Date: 15 March 2024
Our Ref: 24/00191/CLEUD
Please ask for: Mike Halsall

Invalid Application

Proposal: Use of land as commercial equestrian stables business
Location: Walmsleys Barn Wood Lane Heskin Chorley PR7 5NP
Reference: 24/00191/CLEUD

Location Plan shows area bounded by: 353002.77, 415051.2 353144.19, 415192.62 (at a scale of 1:1250), OSGridRef: SD53071512. The representation of a road, track or path is no evidence of a right of way. The representation of features as lines is no evidence of a property boundary.

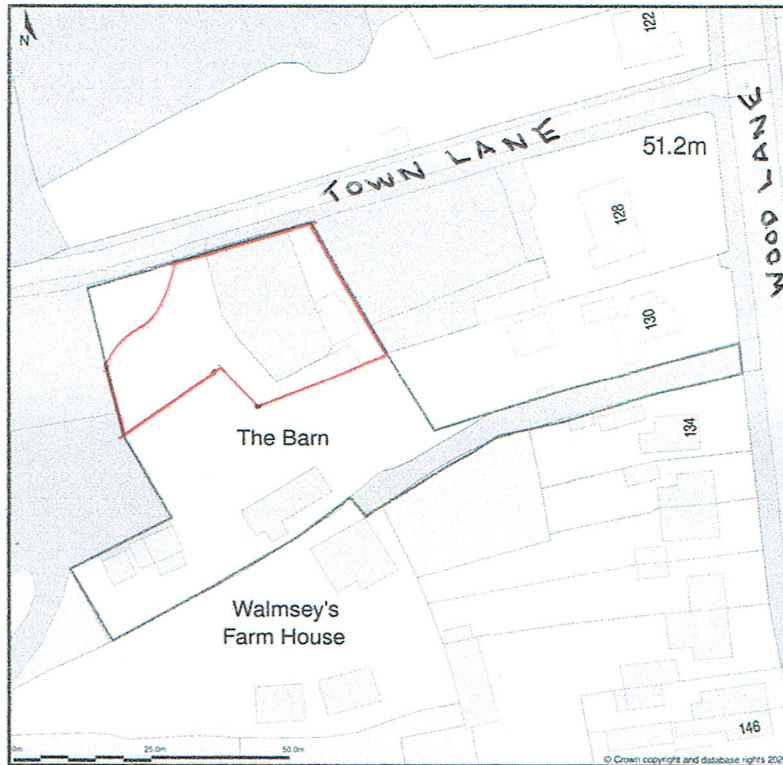
1. Please add street / road names to the Location Plan.
